Planning Officer: Mr S Davis

Planning Application Ref: Y/18/20/PL

Location: Land east of North End Road & West of Church Lane Nursery, Yapton

Description of works: 6no. residential dwellings & associated infrastructure. This application is a Departure from the Development Plan

SK6

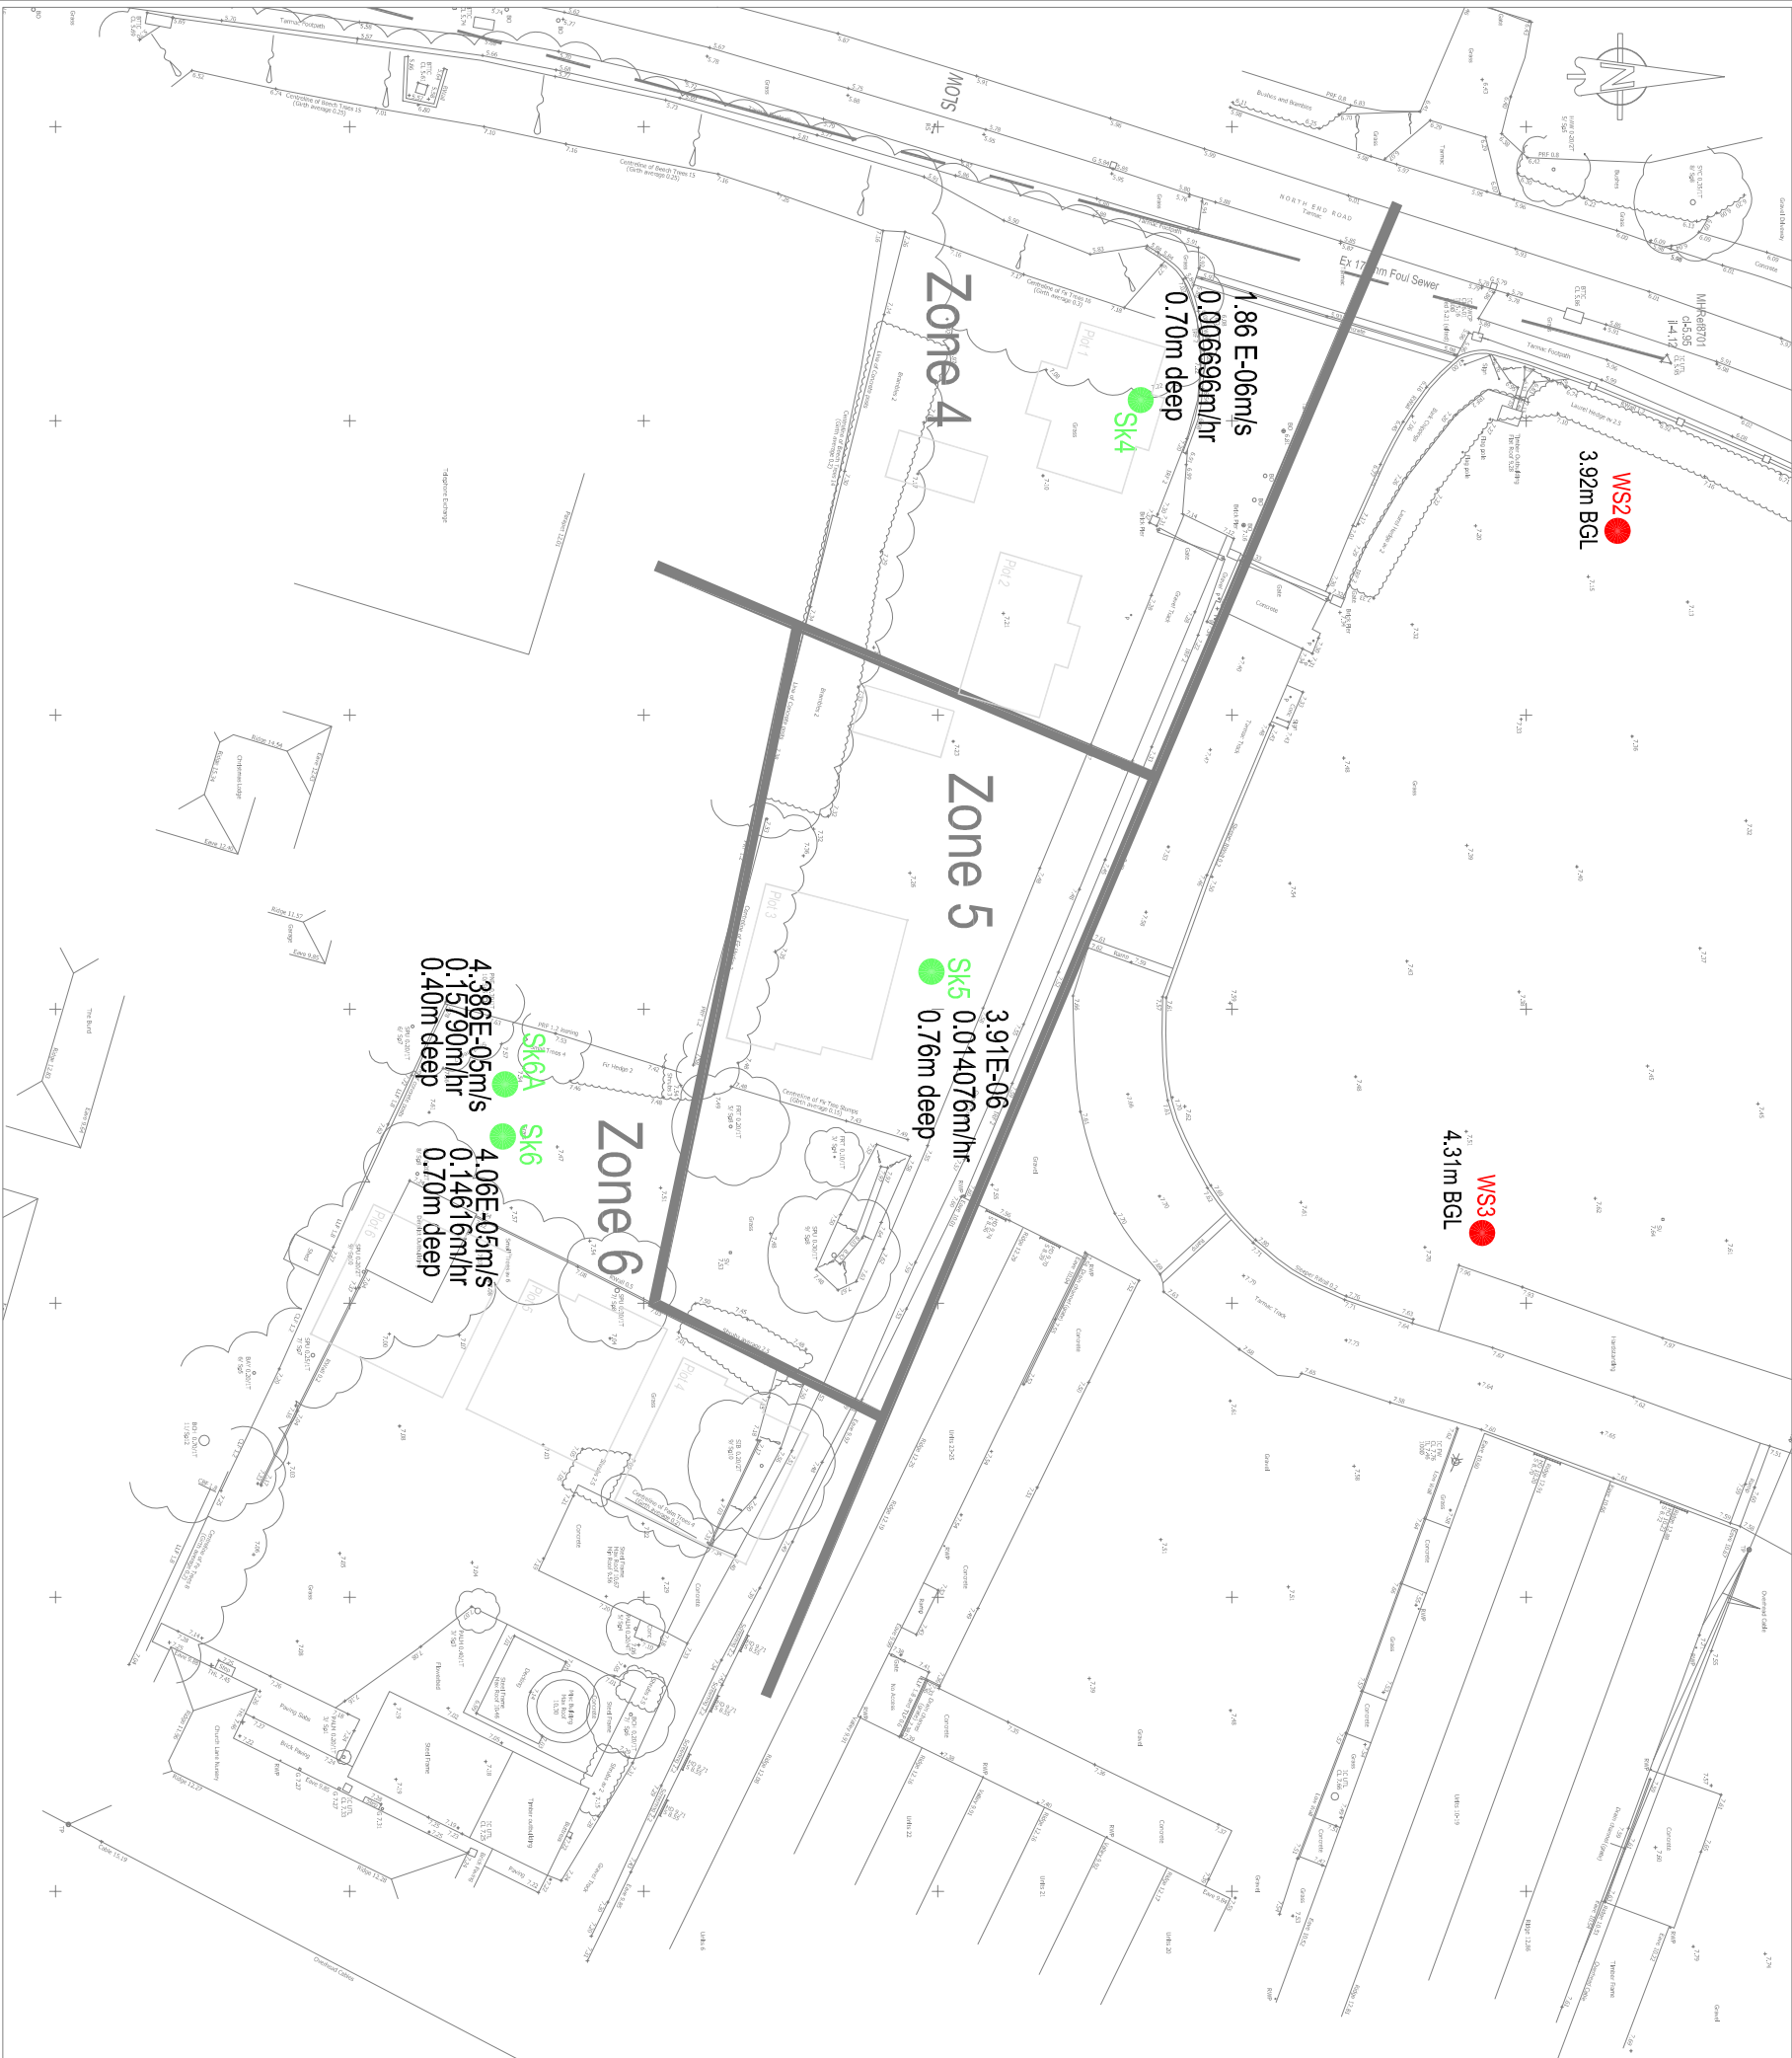
- Subsequent to the above arboricultural submissions, a surface water drainage strategy for the site has been proposed. This fundamental element of the design ought to be addressed to our satisfaction in association with layout proposals, so that we are not subsequently held hostage to flood mitigation measures which could then impact heavily on retained trees/landscape plans.

- I note with great concern, the proposal to install a linear soakaway (Aquacell – is this a ‘crated’ system?) bisecting the rear garden of plot 6. This will presumably involve a deep (>600mm) and damaging excavation far into the root protection area of T3. The location of domestic gravel-filled soakaways at the rear of plots 1 and 2, and west of plot 3 is problematic for the same reasons. I find the extent of these intrusions both unacceptable and avoidable, so expect the applicant’s engineer to revisit those elements of the strategy. Furthermore, were those soakaways to be installed at the current proposed locations - future tree growth (roots) could rapidly infiltrate and reduce their effectiveness.
